November 10, 2022

**Sites: Coors Pavilion Subdivision – 4111 Coors Blvd NW - G11E069**

**Re: Drainage Ordinance (14-5-2-11) Violations for Erosion and Sediment Control**

C-1

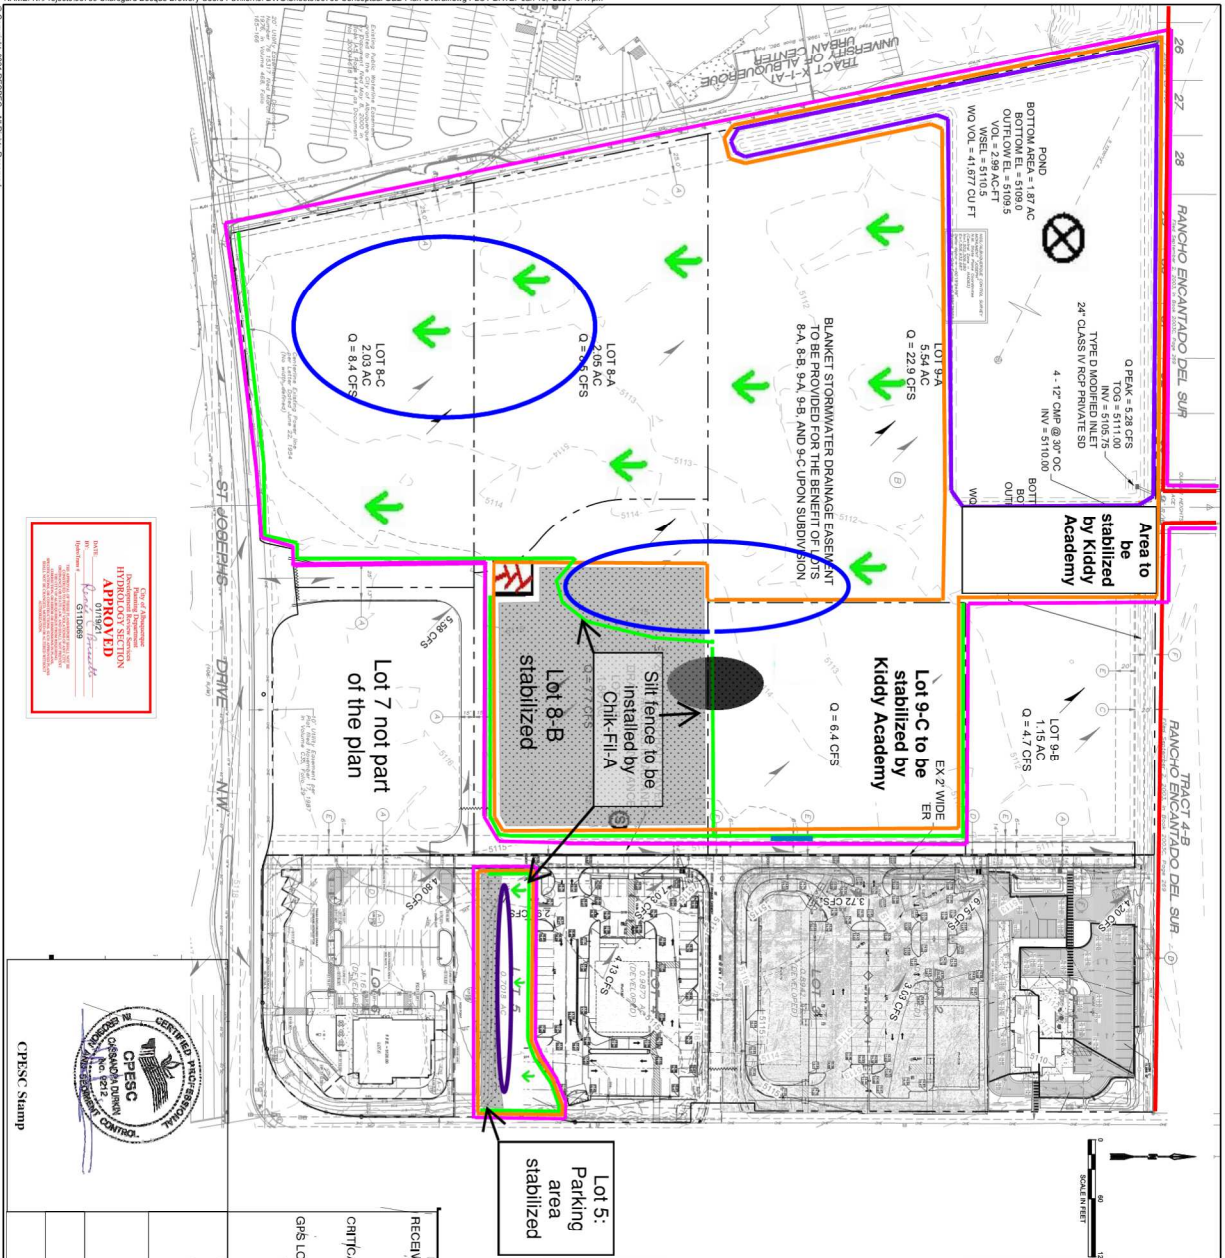
2. BMPs – The silt fence (SF) is still falling down and hasn't been repaired or replaced on lots 5 and 8B, and it has been more than 7 days since the sediment and SF were noted in the most recent inspection report.

3. The SWPPP wasn't up-to-date. The Silt Fence (SF), shown on the map on lots 5 and 8B, wasn't installed, and the missing SF wasn't noted on either the map or a corrective action report. The latest self-inspection report was dated 10/28/22 and it noted the sediment and missing silt fence. Since the ESC Plan wasn't approved by the City until 10/31/22 there is good reason why and the missing SF wasn't noted on either the map or a corrective action report, however there isn't any excuse for not having removed the sediment and installed the SF.

1. Where sediment has been tracked-out from your site onto paved roads remove the deposited sediment by the end of the same business day CGP 2.2.4.d,
2. BMPs – Silt Fence (SF) must be reset on lots 5 and 8B as shown on the map. The SF is probably not needed on the north and west sides of lot 8B.
3. The SWPPP must be kept up-to-date and available on site. Corrective Action is required for the missing SF and the sediment in the street. Clearly identify the corrective action report in the SWPPP and note the need to update the SWPPP if the SF is deleted on the north and west sides of lot 8B per CGP 5.4 and CGP 5.2.1.c.
